From: Anita Gardner <Anita.Gardner@arun.gov.uk>
Sent: 03 March 2020 09:39
To: Planning.Responses <Planning.Responses@arun.gov.uk>
Subject: FW: Decision Notice DOC Individual Actual PLDNDOCIACT [14 Coastal Road]

Thank you for the Decision Notice for K/2/20/DOC, which confirms acceptance of Condition 7 [materials and finishes]. The Condition submission also covered Condition 4 [balcony glazing details]. Can you confirm that this is also covered by the Decision Notice?

REV.	DATE	DESCRIPTION
PROJECT		
14 COASTAL ROAD EAST PRESTON BN16 1SJ		
DRAWING		
PROPOSED EAST & SOUTH ELEVATIONS		
CLIENT		
MRS & MR CLARKE		
SCALE	DRAWN	
1:50 @ A1 / 1:100 @A3		
DATE	CHECK	
FEBRUARY 2020		
DRAWING No.	REVISION	
1714- PL1-09	D	
© copyright retained

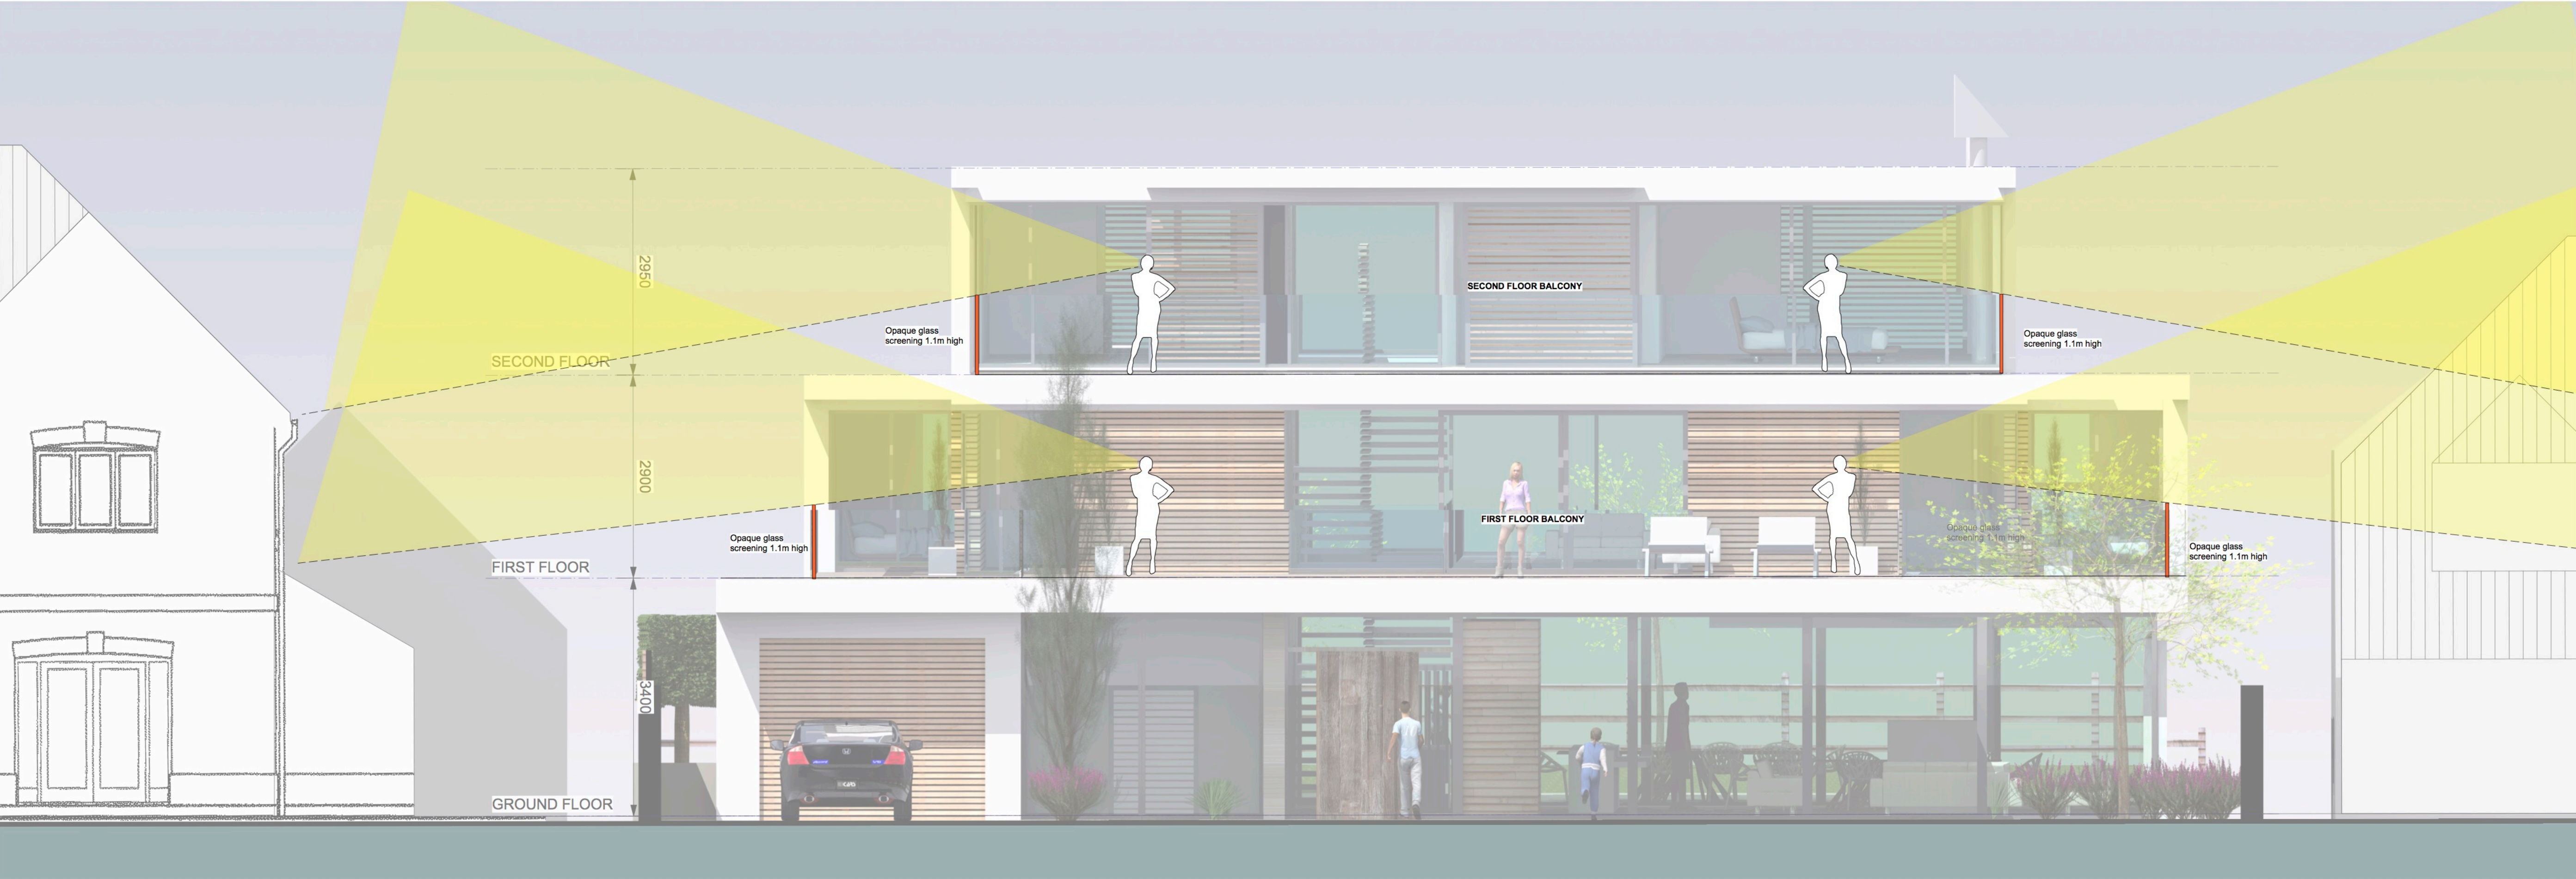
Having had an initial look at the details submitted I am of the view that the height of the screening to some balcony sides will need to be increased to 1.7m high, but I need to consider the balcony position and screening on the original dwelling to establish where this would be required and come back to you. I can advise that the application in its current form will be refused if it is not subsequently amended.

Hi Sarah,
To speed up the discussion process and to avoid any confusion can you submit first and second floor layout plans with the extent and height of balcony screening to the east and west elevations clearly marked.
Regards
Anita

Apologies for the further email on this but my client also wishes to point out that the previous house on the site had a balcony along its frontage which wrapped around its sides, which only extended to 1.1m in height and had cleared glass all around. The situation proposed at 1.1m height on the side elevations with obscure glazing therefore delivers an improvement. The existing elevations attached demonstrate and the photos within the DAS [also attached].

When you speak to your Team Leader, please could you advise him that my client has been advised that higher balconies are not advised because of the high winds experienced here. The approved plans also show the balcony screens to 1.1m high. This is considered acceptable because the balconies are placed to the frontage of the building and over look open, front gardens with low dwarf walls at their front boundary, rather than private, rear spaces where, ordinarily higher levels of privacy are experienced. The only rear balcony is also adjacent to an area used for car parking.

REV.	DATE	DESCRIPTION
	52.11	
PROJECT		
14 COASTAL ROAD EAST PRESTON BN16 1SJ		
DRAWING		
PROPOSED FIRST FLOOR PLAN		
CLIENT		
MRS & MR CLARKE		
SCALE		DRAWN
1:50 @ A1 / 1:100 @A3		CHECK
DATE		REVISION
FEBRUARY 2020		L
DRAWING No.		
1714- PL1-06		
© copyright retained

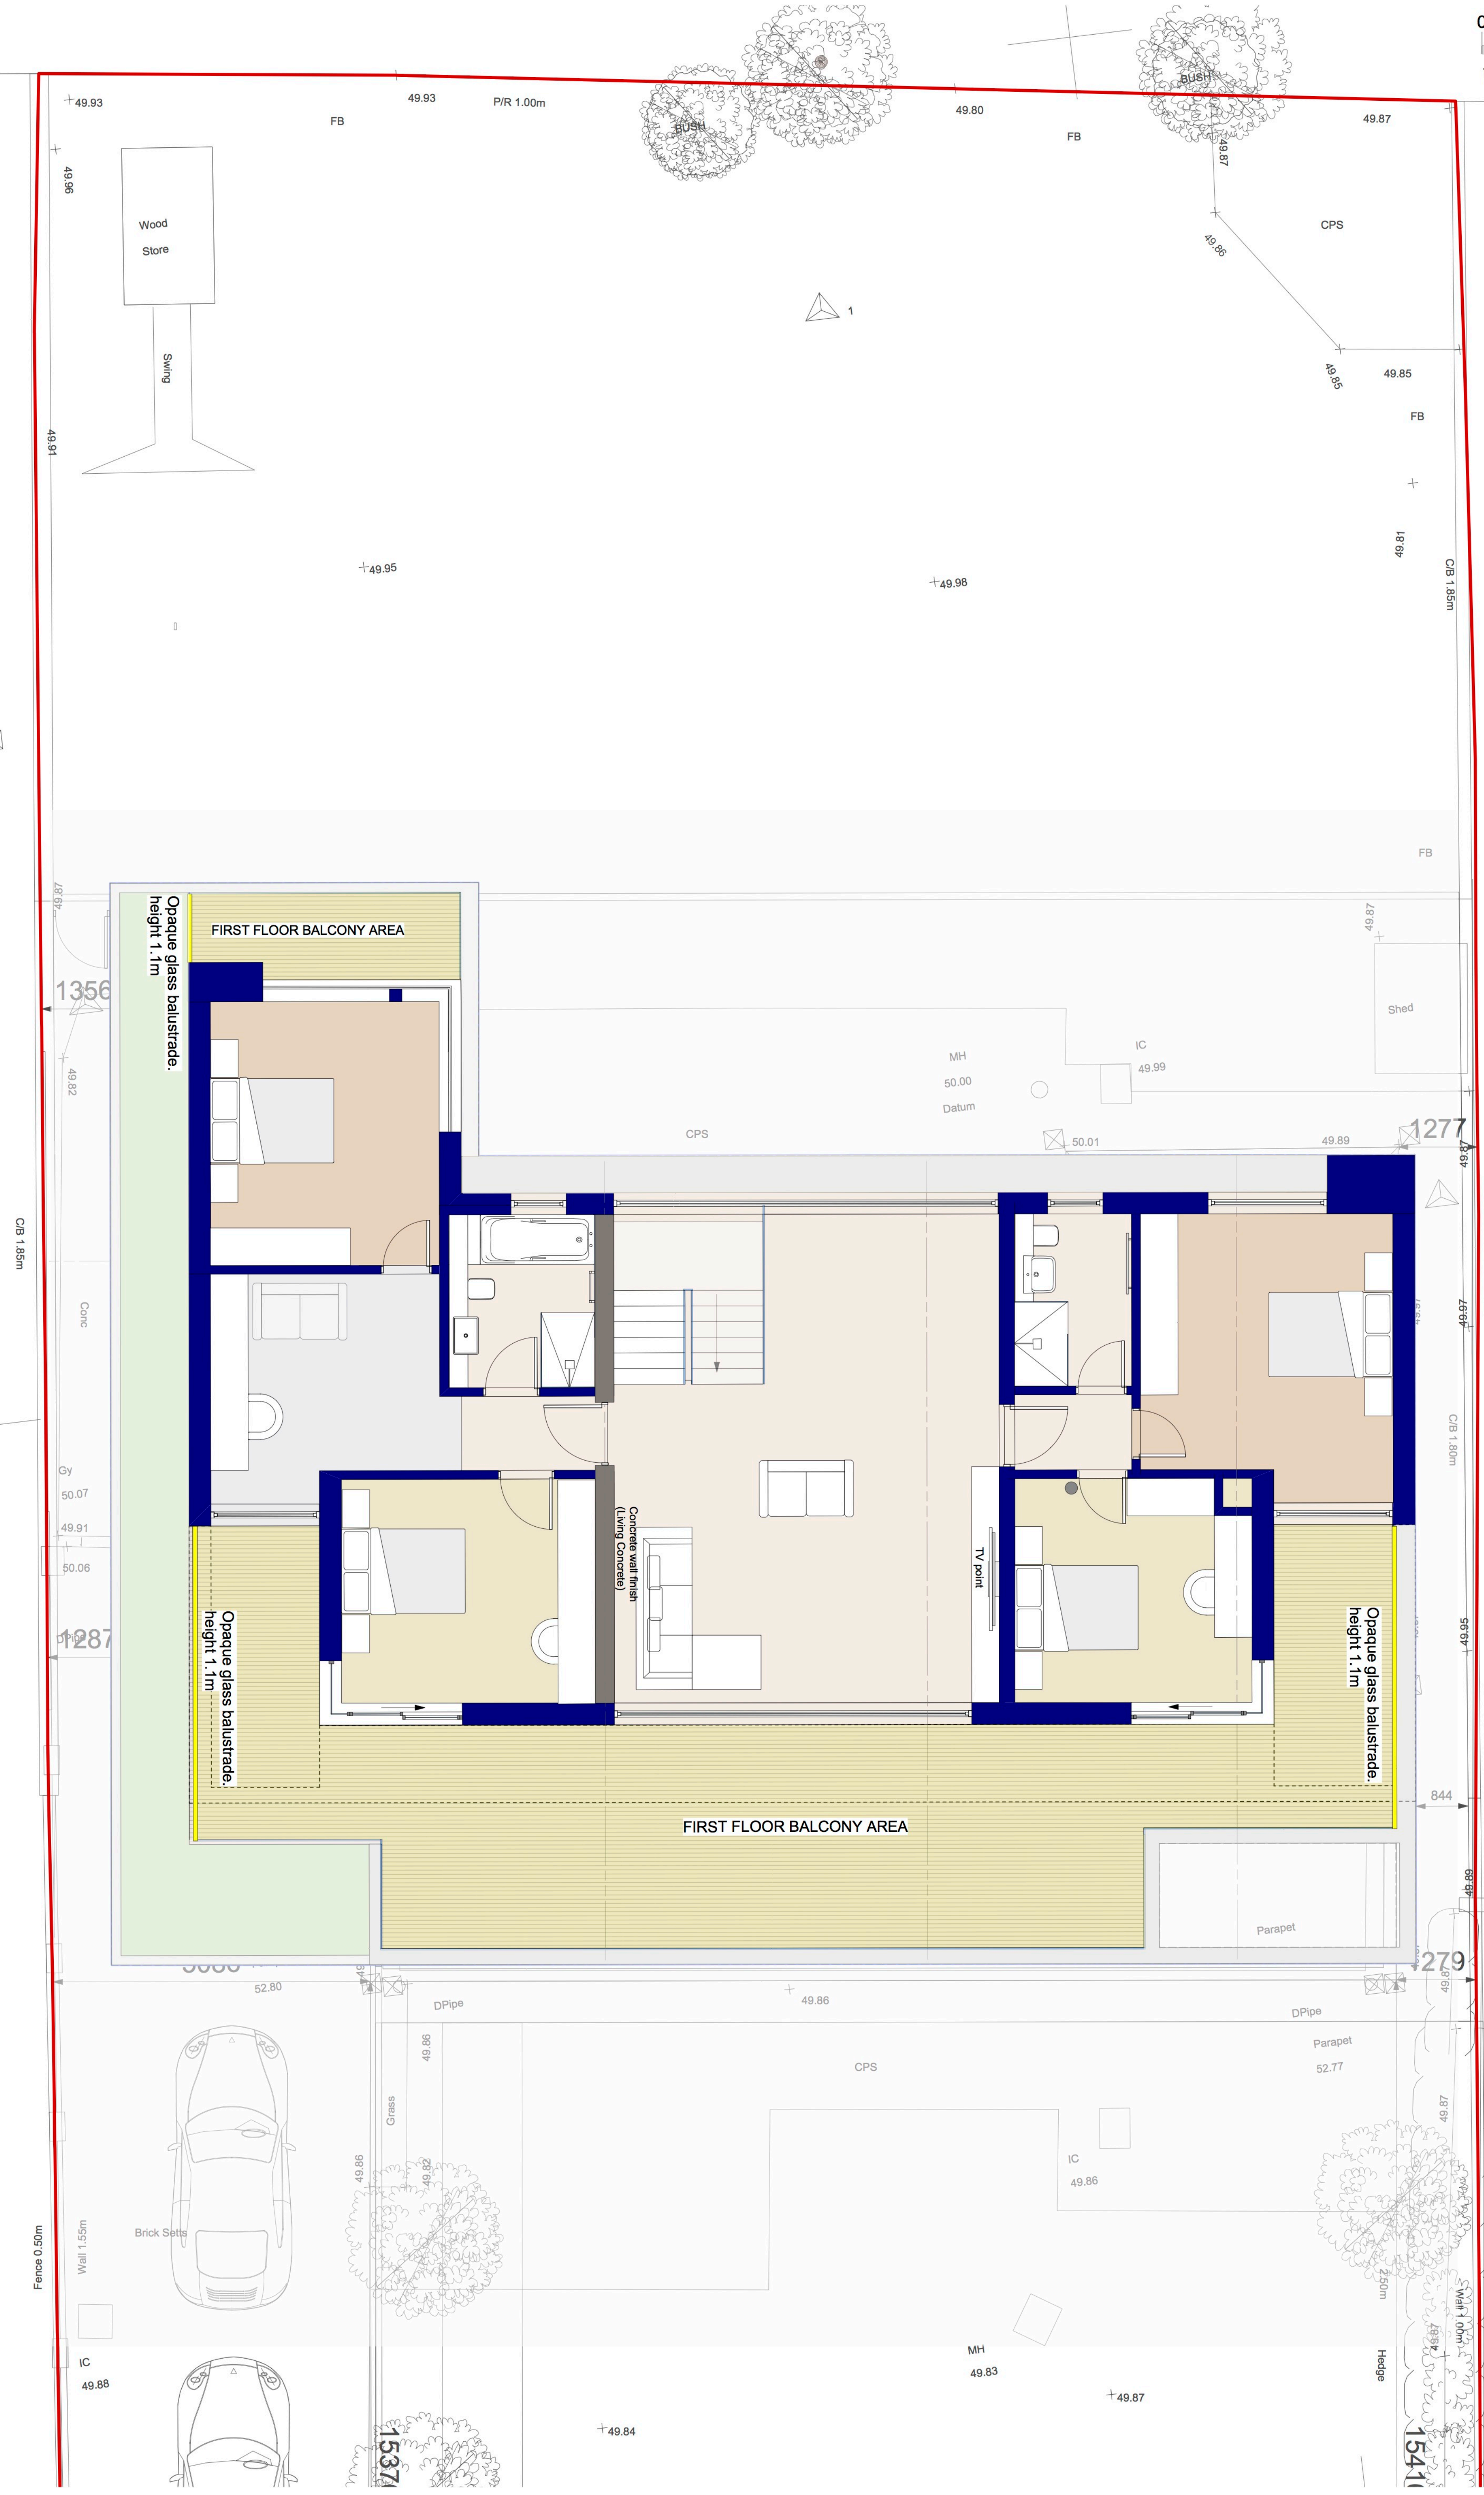
To clarify the extent of screening proposed for the roof terraces/balconies at first floor can the extent of clear glass balustrading be identified on the proposed first floor plan please?
